Ryder Truck Rental

**CITY OF PORTLAND, MAINE
DEVELOPMENT REVIEW APPLICATION
PLANNING DEPARTMENT PROCESSING FORM**

Re: Rider Truck Rental, Inc.
Building Extension
Pine Tree Industrial Parkway
Portland, Maine

Your application to construct service bay and to make interior renovations has been reviewed and a permit is herewith issued subject to the following requirements: This permit does not excuse the applicant from meeting applicable State and Federal laws.

ENCLOSURE PLAN & DETAILS

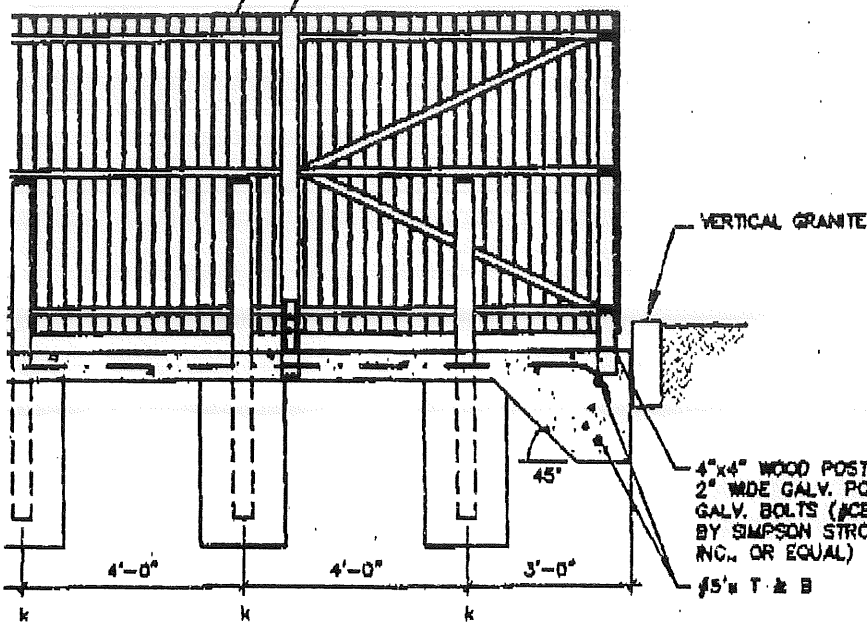
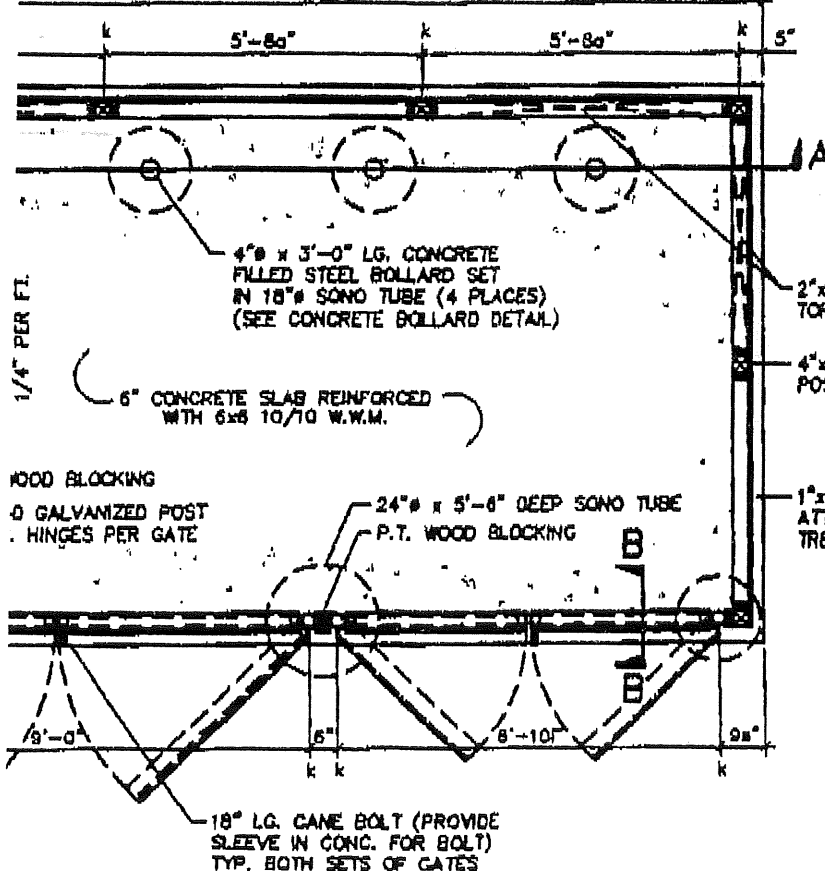
Building Inspection : Approved M. Schmuckal
Development Review Coordinator : Approved J. Seymour
Fire Dept.: Approved Lt. McDougall
Planning Div.: Approved with conditions that the dumpster shall be enclosed prior to the issuance of the certificate of occupancy. 2. Three (3) pine trees shall be added to the rear of the property near the southwest corner of the building . K. Talbot

1. Existing dumpster shall be enclosed prior to issuance of certificate of occupancy.
2. Three (3) Pine trees shall be planted to the rear of the property near the southwest corner of the building.

1. The three pine trees shall be planted along the rear of the property near the southwest corner of the building.
 2. The dumpster shall be enclosed.
- cc: Kathi Staples, P.E., City Engineer
